Recommendation Report for Planning Permission for Works or Extension to a Dwelling

REF NO: EP/121/20/HH

LOCATION: 49 Manor Road
East Preston
BN16 1QA

PROPOSAL: First floor extension over existing garage

PROPOSED ELEVATIONS

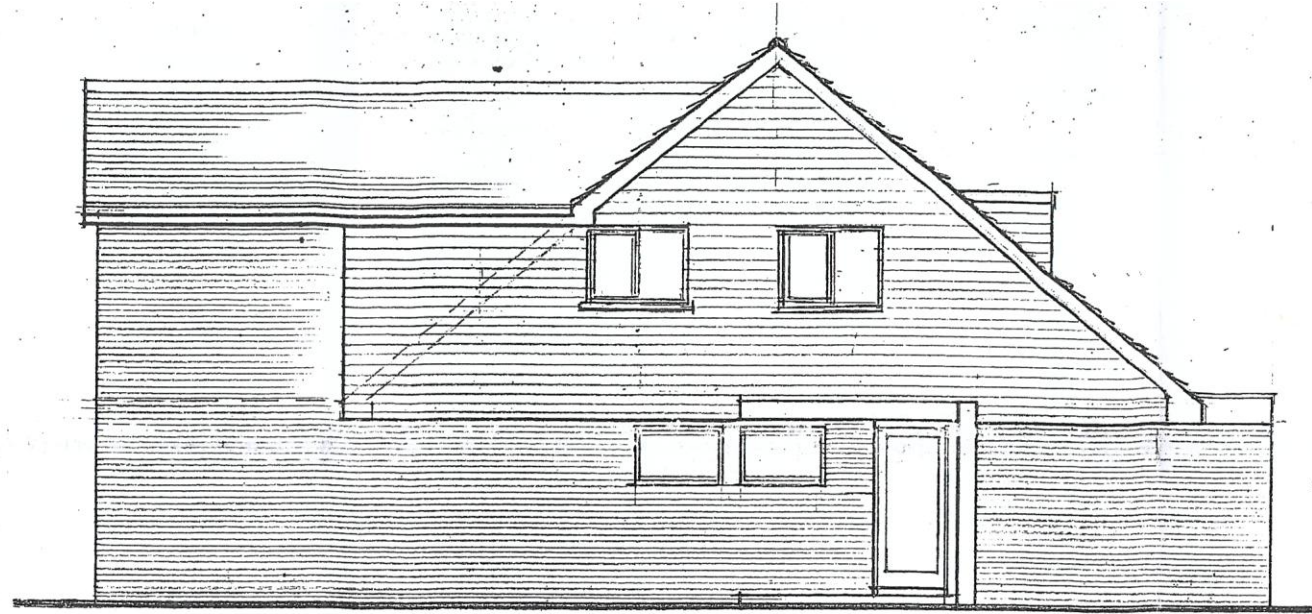
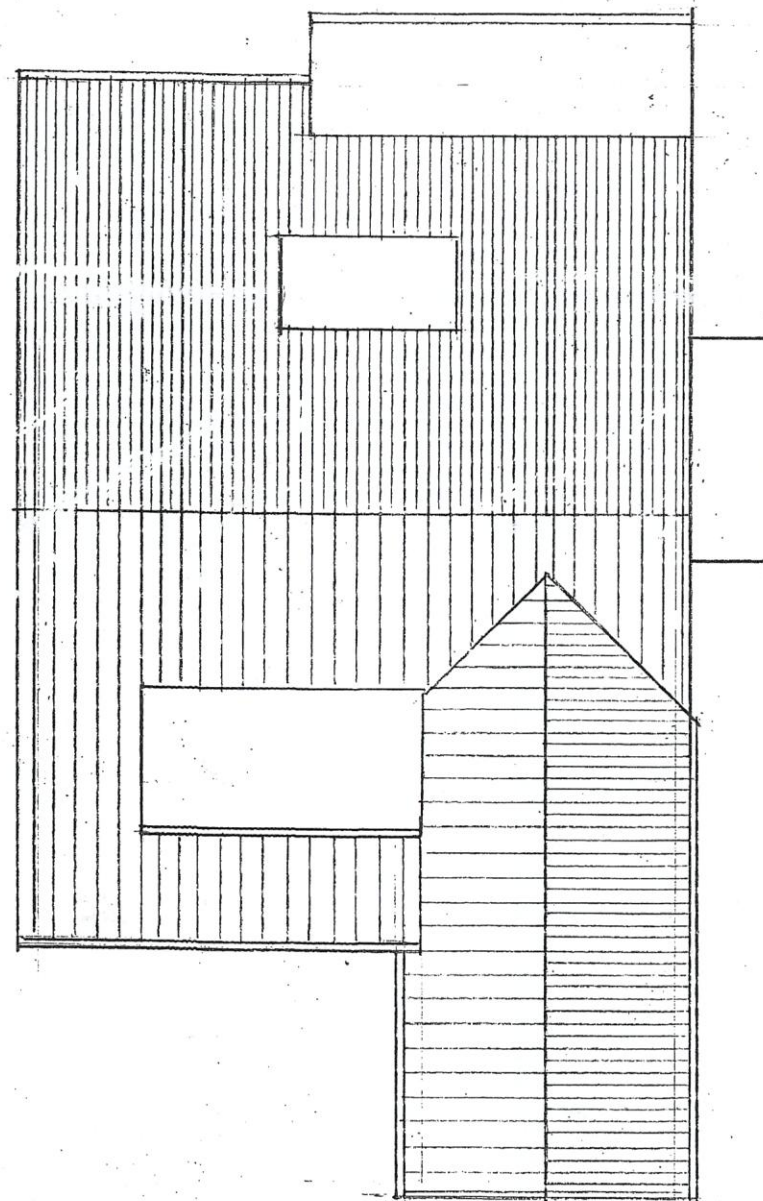
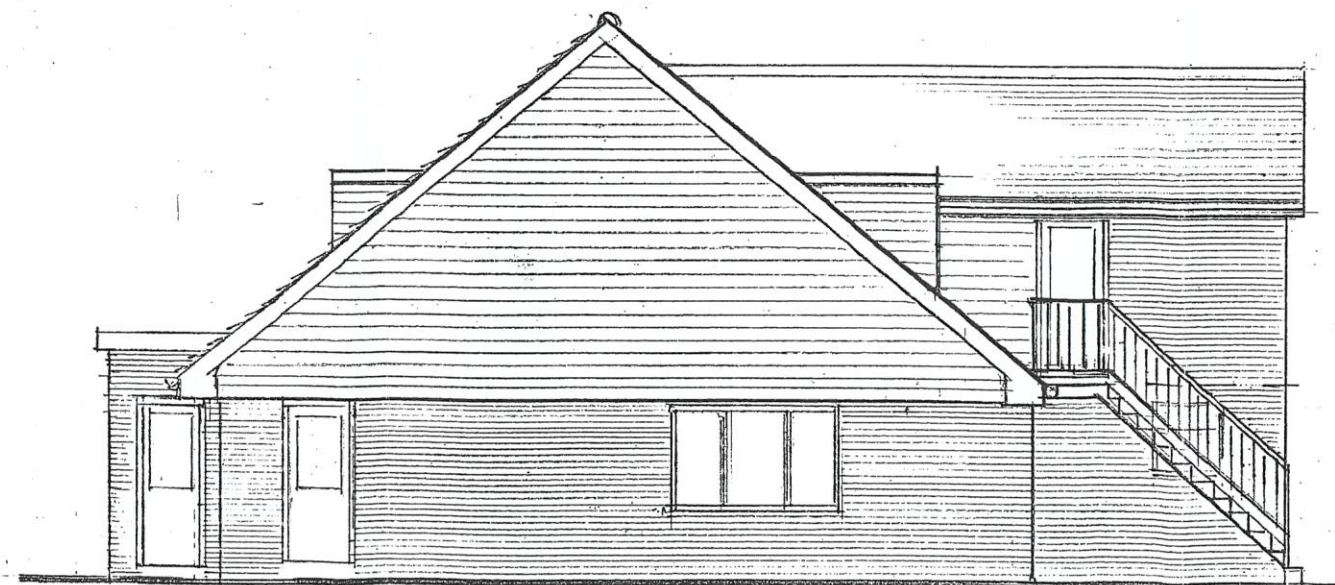
The property has a garage to the front elevation and this will be extended to a height of 6.7m allowing a first floor to be added which will run alongside the eastern boundary with a depth of 8.15m. The proposed development will have an external staircase to the west (the submitted plan wrongly shows it as being on the east elevation) of the first floor addition.

As a result of the size and its siting, the proposal adds significant bulk to the front elevation of the property which will be highly visible from the street scene. Whilst the property is set back from the road, the proposal is still deemed to appear a dominant addition to the street scene.

The extension to the top of the garage will have a gable roof and will abutt the side boundary.

Given the significant extent of the extension and its close proximity to the neighbouring property to the west, a bungalow, there will be oppressive and overbearing effects on their residential amenity/outlook. However, there will be no unacceptable overlooking from the extension given the absence of any windows on the proposed elevations.
